**KIRKLEES METROPOLITAN COUNCIL
INVESTMENT & REGENERATION SERVICE**

**DELEGATED DECISION TO DETERMINE PLANNING APPLICATIONS TO
CARRY OUT DEVELOPMENT WITHOUT COMPLIANCE WITH PLANNING
CONDITIONS PREVIOUSLY ATTACHED**

Reference No:	2026/70/90833/E
Site Address:	Springfield Farm, 15, Moorside, Cleckheaton, BD19 6JH
Description:	Variation of conditions 2 (plans) and 8 (materials) on previous permission 2025/91534 for erection of stable block and formation of riding menage
Recommending Officer:	Danielle Cooper

Officer Report

drawing: Proposed Floor Plan & Elevations

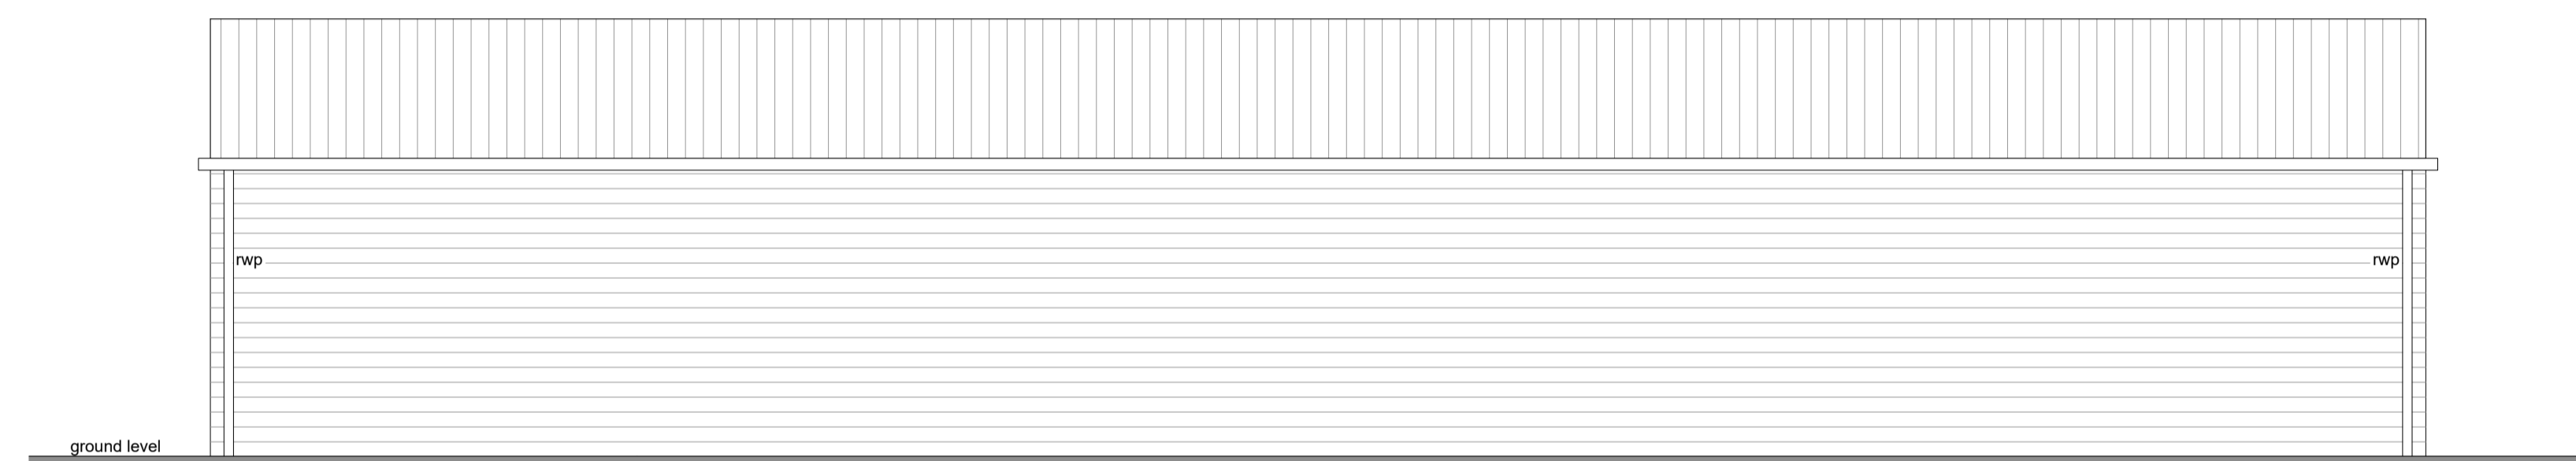
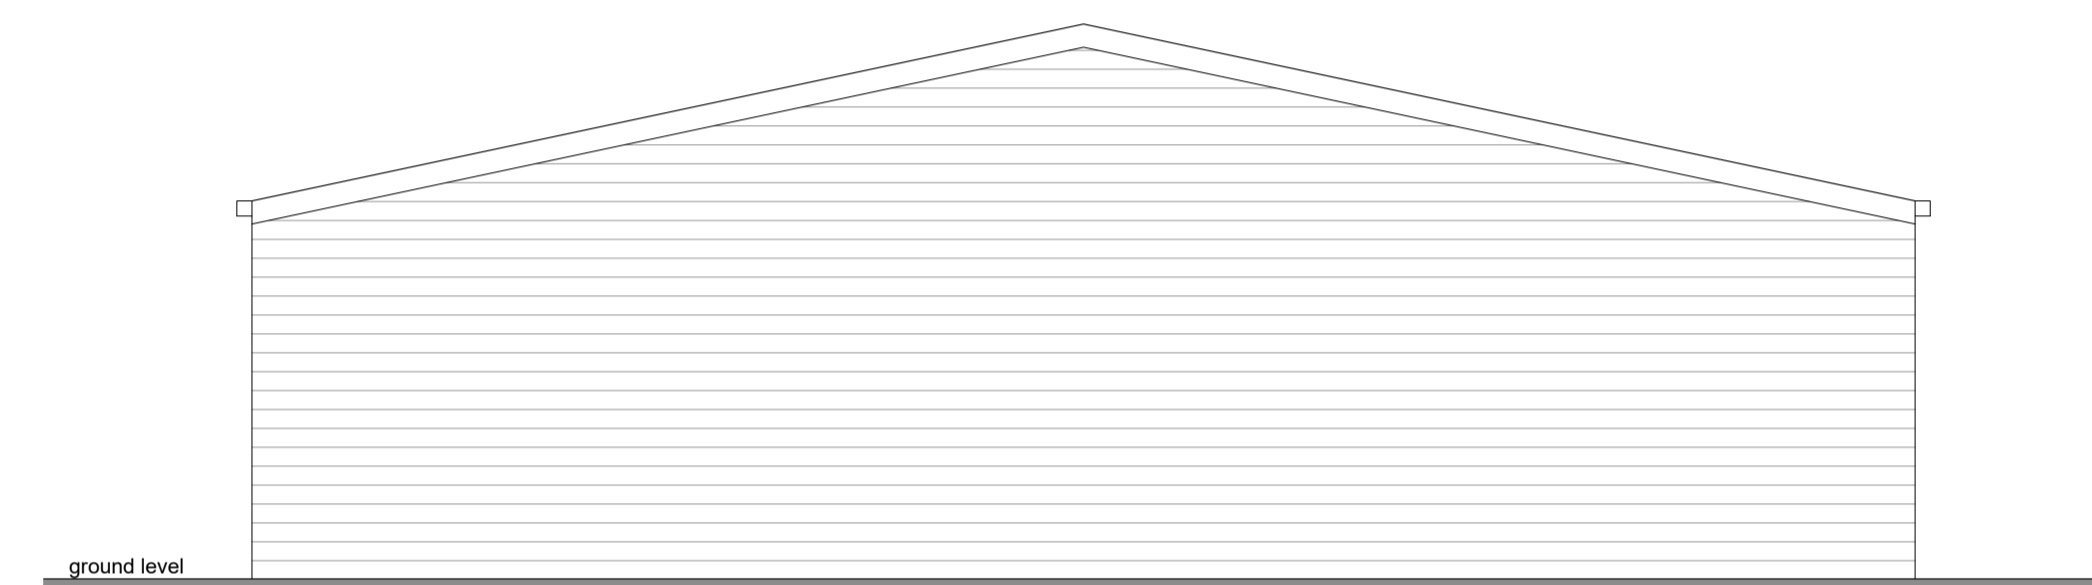
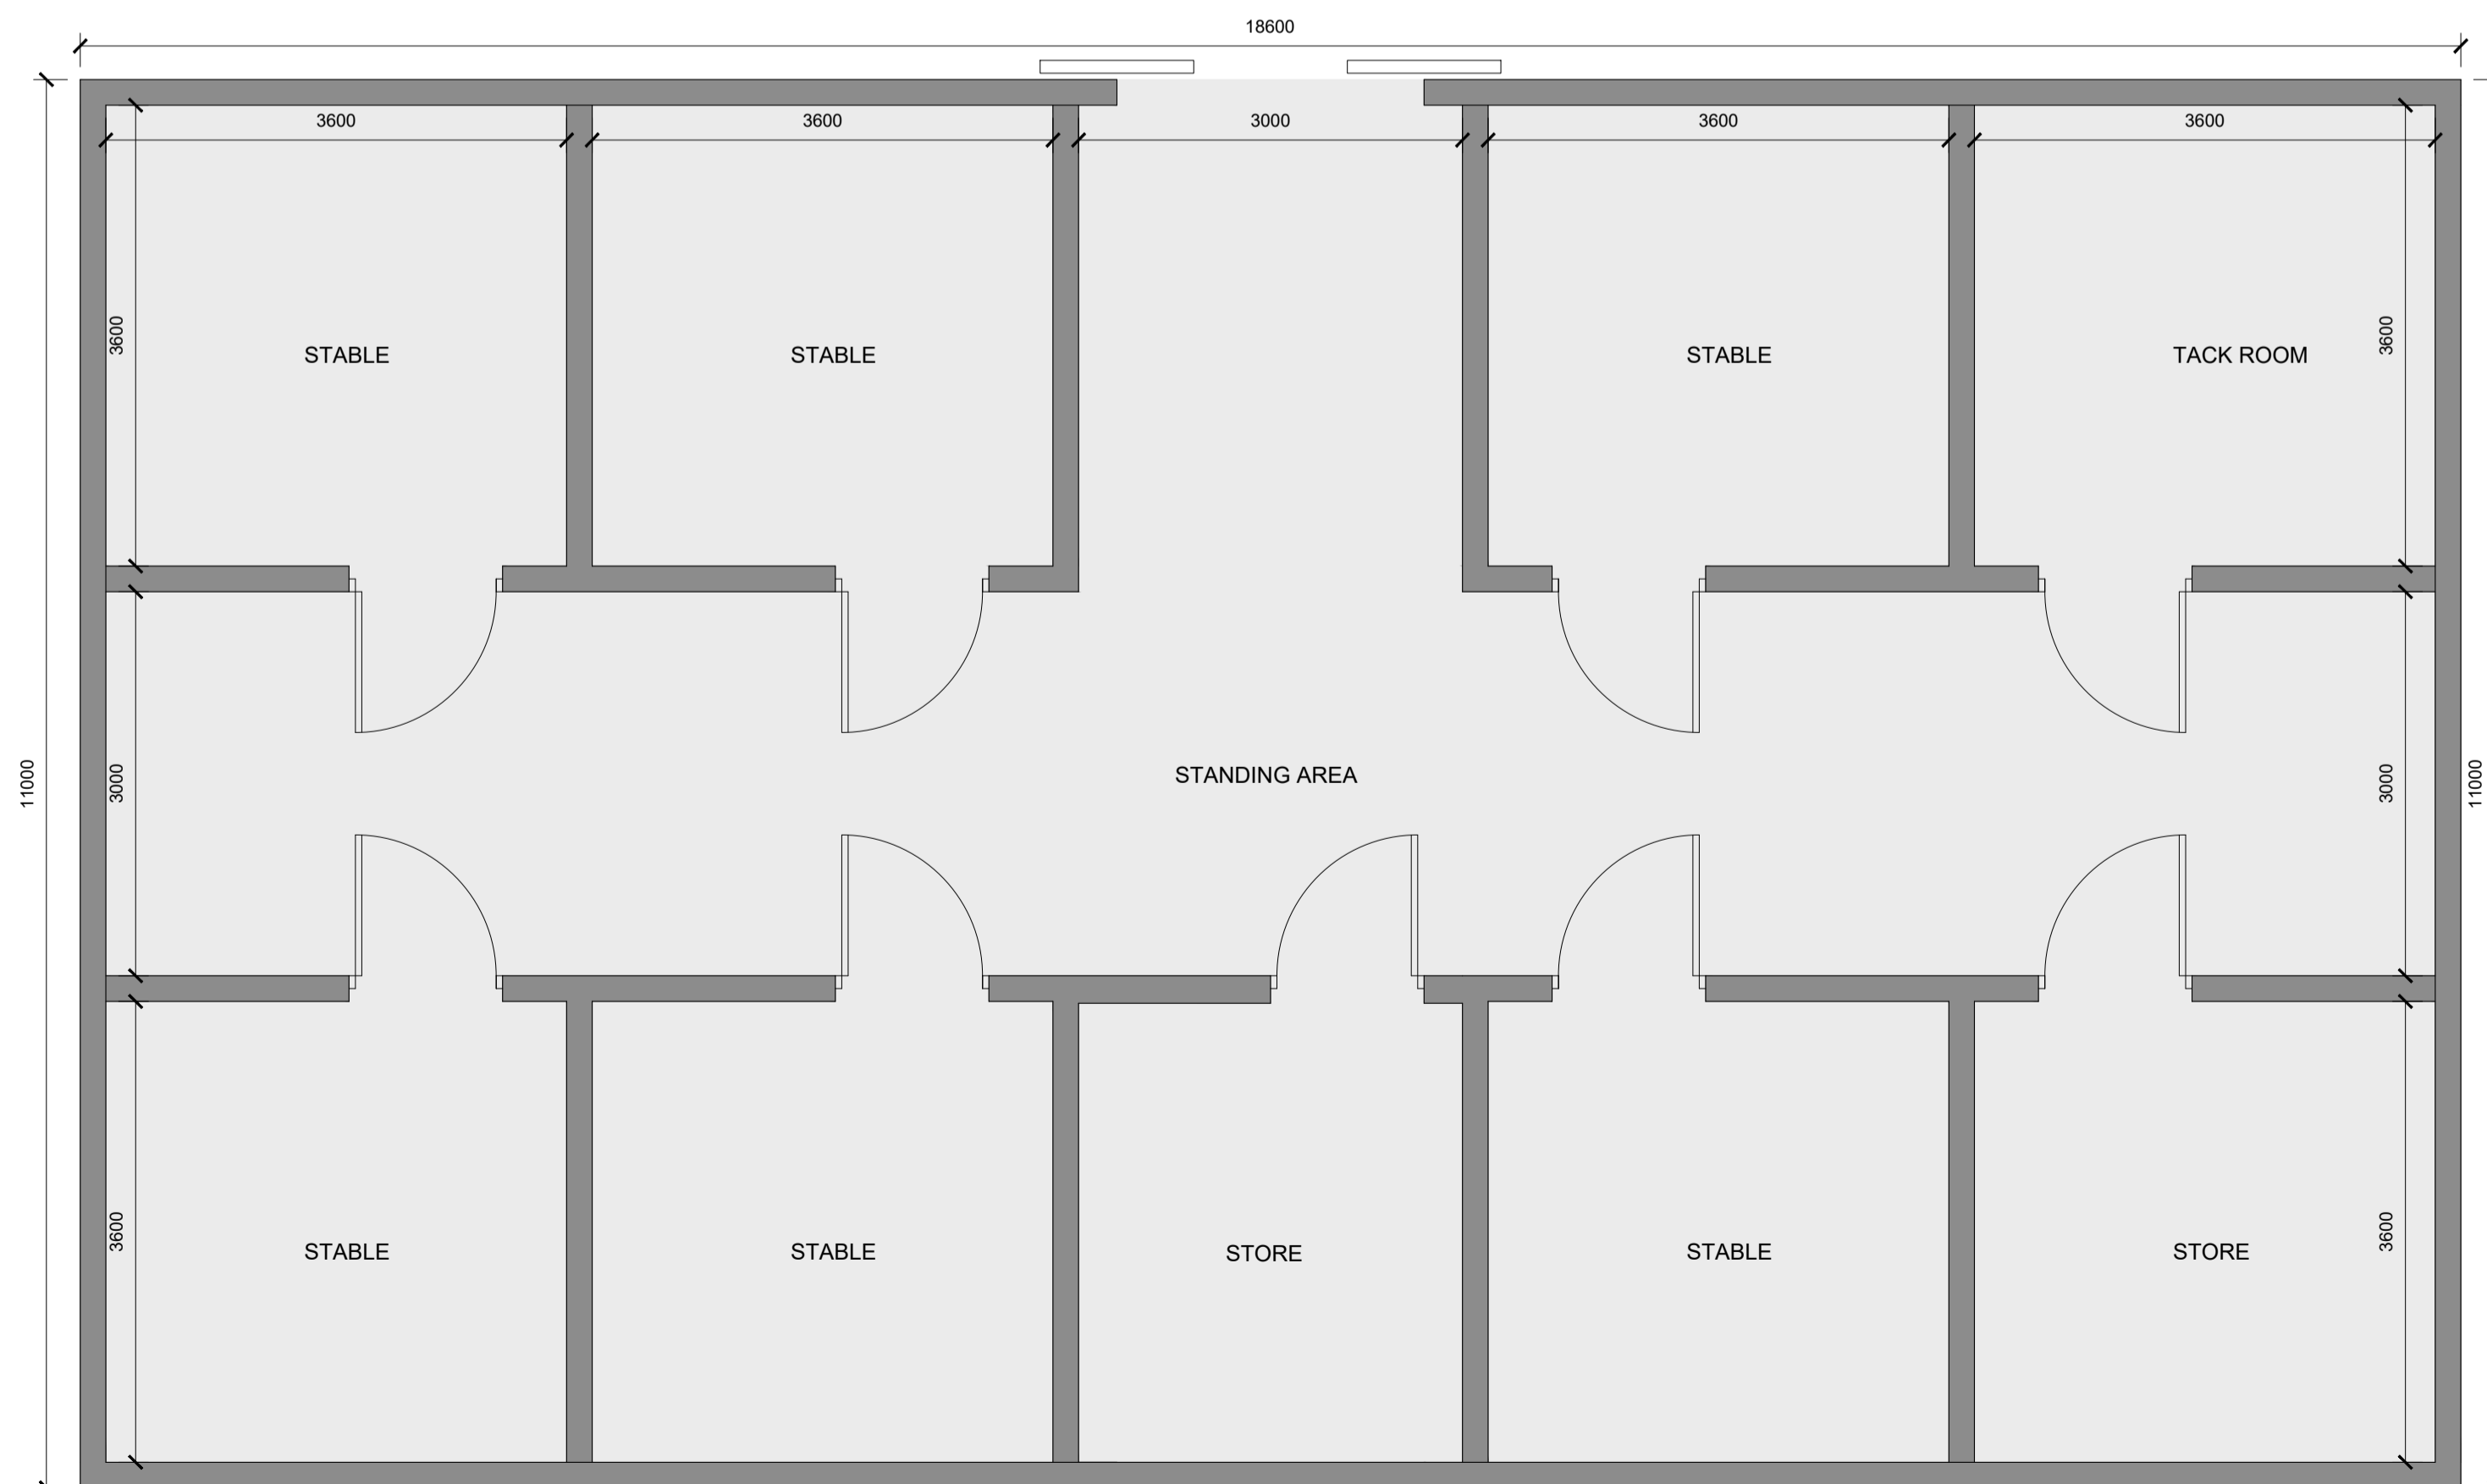
“8. The building hereby approved shall be constructed in accordance with the materials of construction as detailed upon submitted drawing ref: 03. The roof of the building hereby approved shall be of a black or dark brown or dark

Due to the proposed alterations as explained above, new proposed elevation plan has been submitted and as such the plan identified within condition 8 is sought to be updated.

The building hereby approved shall be constructed in accordance with the materials of construction as detailed upon submitted drawing ref: 26-003-01 Rev A. The roof of the building hereby approved shall be of a black or dark brown or dark green colour finish. The development shall not be brought into use until it has been completed with the materials and colour finishes approved by this condition.

Proposed Barn

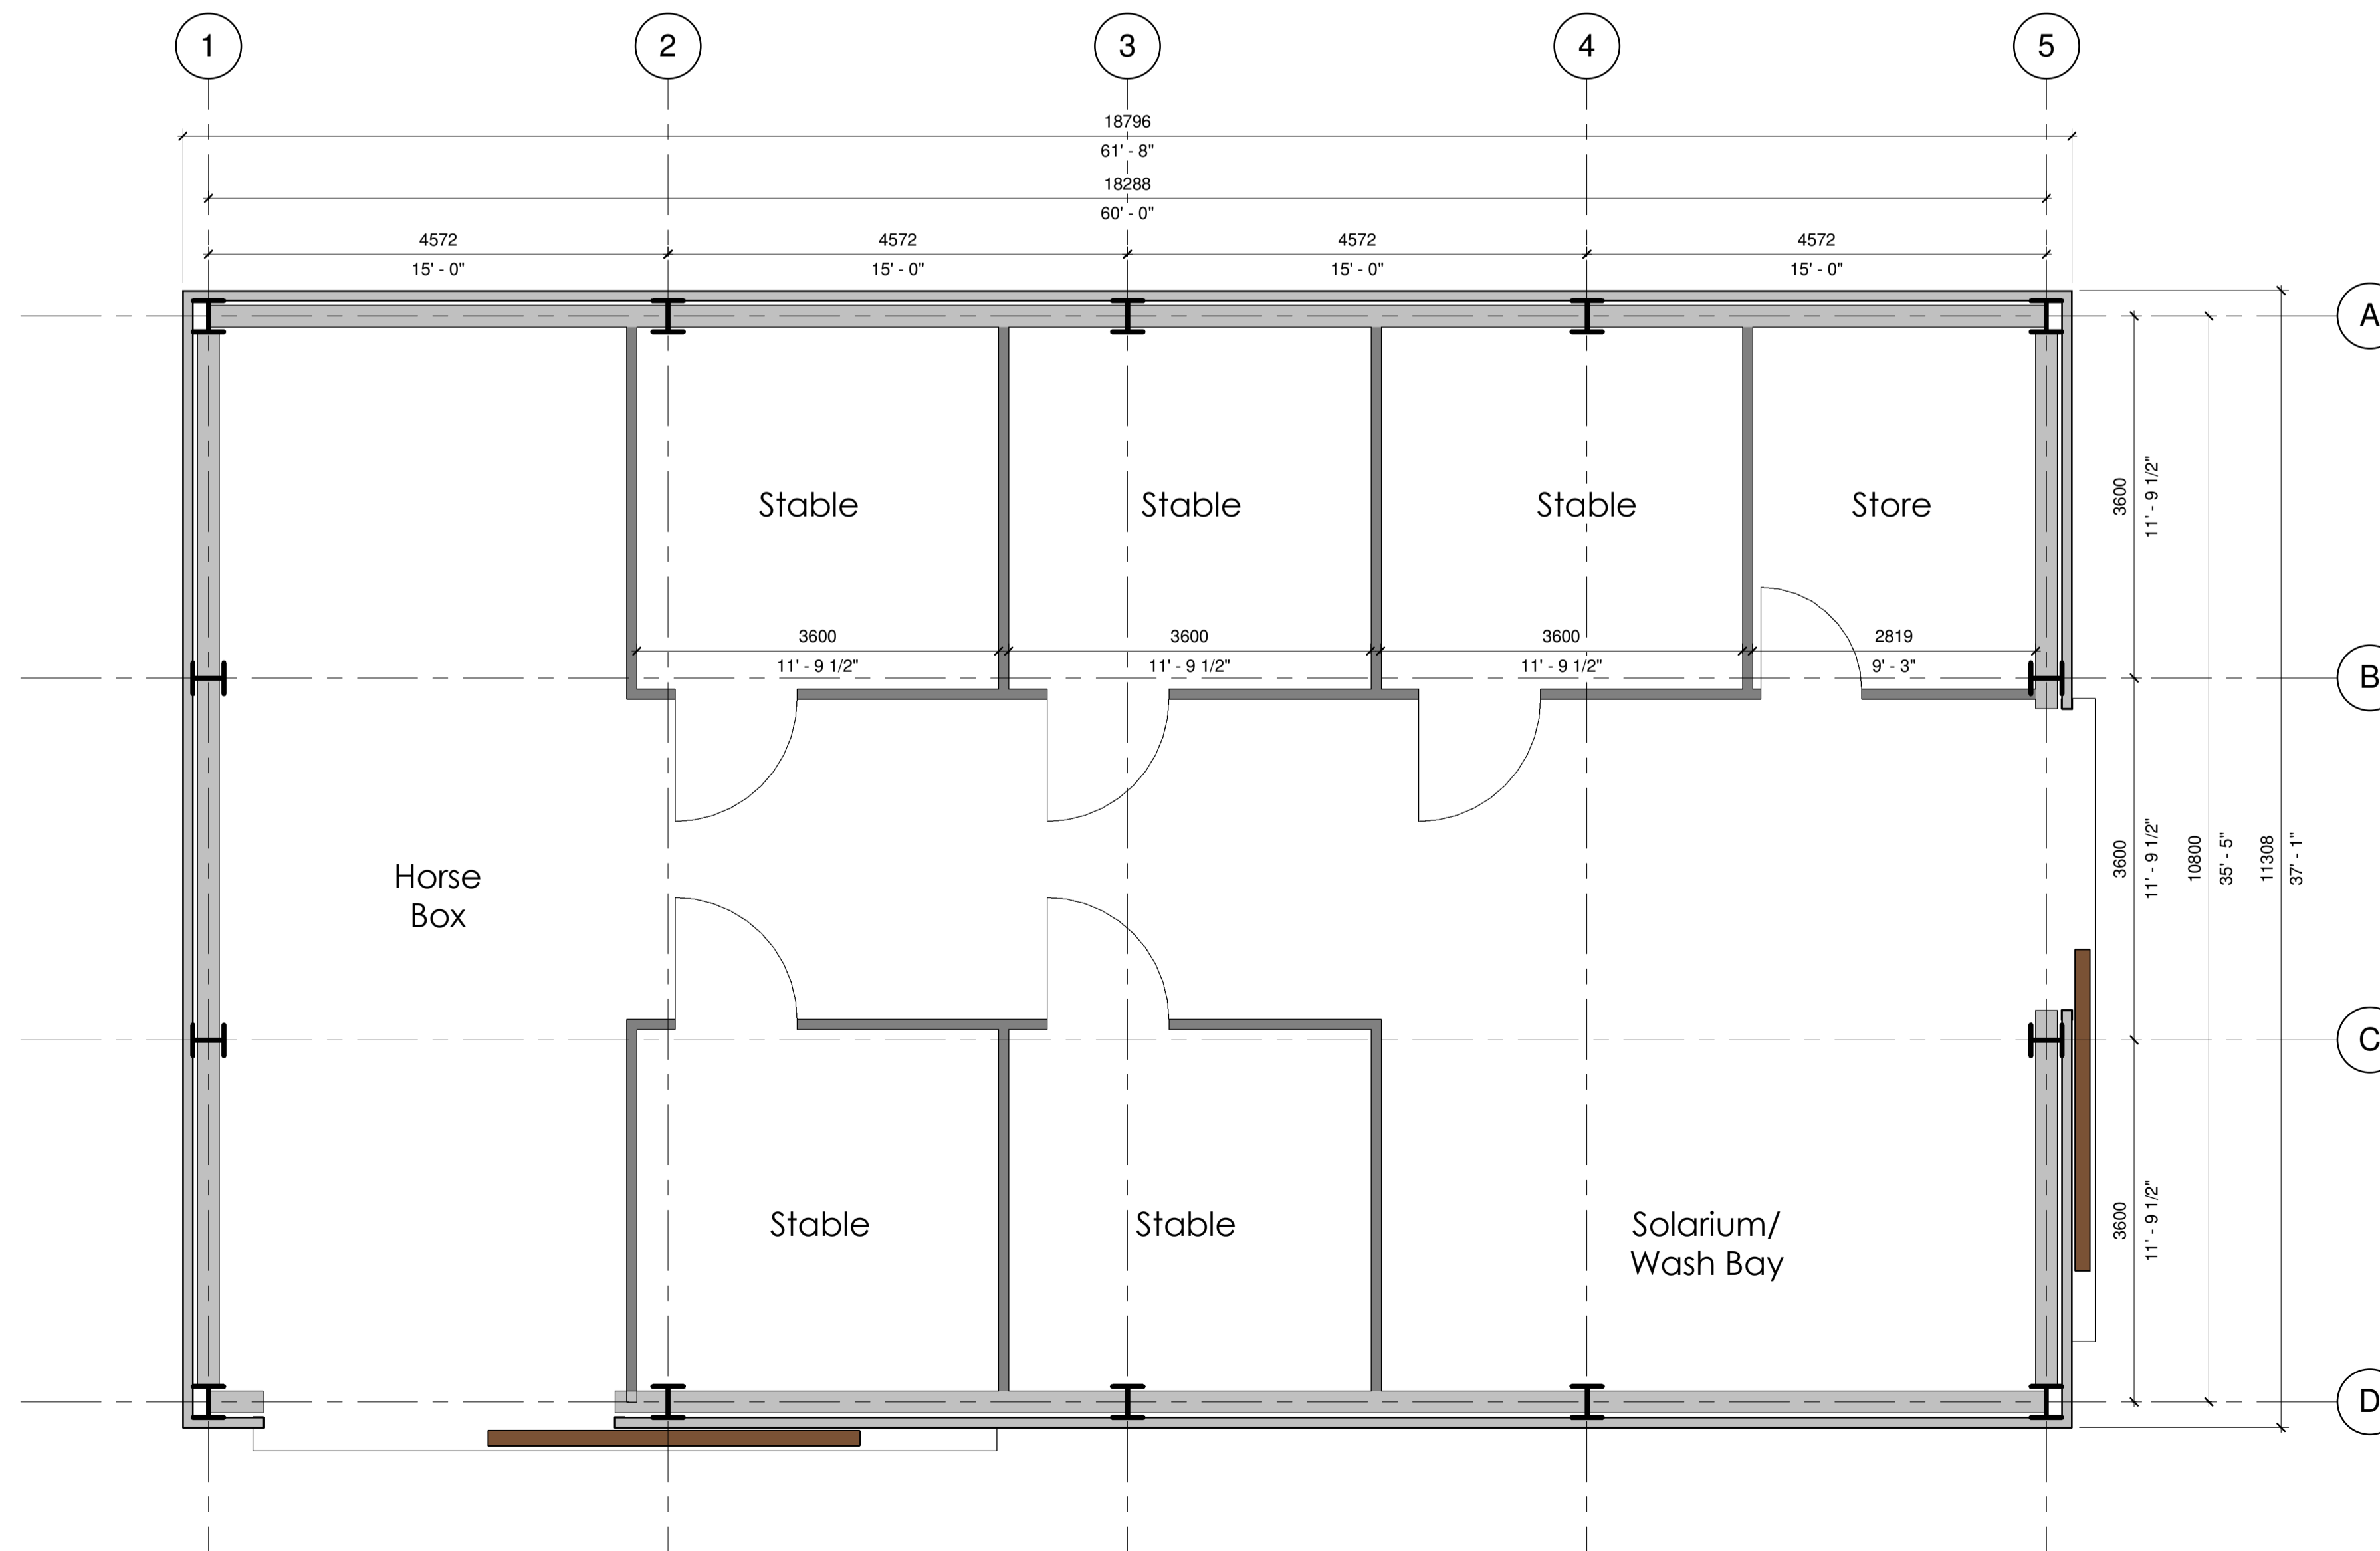
The length of the building has been increased from 18.6m to 18.76m and the width of the building has been increased from 11m to 11.3m. The eaves of the building has been increased from 2.5m to 4.9m and the ridge height from 3.6m to 5.9m.

The updated plans also show the building to have two sliding doors. One of the side and one on the front elevation.

The proposed alterations relate to the approved stables. It is proposed that the length of the building is increased from 18.6m to 18.76m and the width of the building is increased from 11m to 11.3m. The eaves of the building has been increased from 2.5m to 4.9m and the ridge height from 3.6m to 5.9m. The updated plans also show the building to have two sliding doors. One of the side and one on the front elevation.

The proposed increase in the footprint of the stables is considered minor and does not raise any concerns. While the ridge and eaves heights will be increased significantly compared with the approved scheme, the agent has explained that the additional height is required to ensure the building functions effectively. The proposed height will also align with that of the adjacent agricultural building. Given the rural context—characterised by open fields and other agricultural structures of comparable scale—the increased height and overall scale are regarded as visually acceptable and will not harm the character or appearance of the surrounding area. It is further noted that the building will not be readily visible from public vantage points within the streetscape.

The proposal also includes amendments to the building's openings, introducing two sliding doors. These changes are considered to integrate well with the overall design and raise no visual concerns.
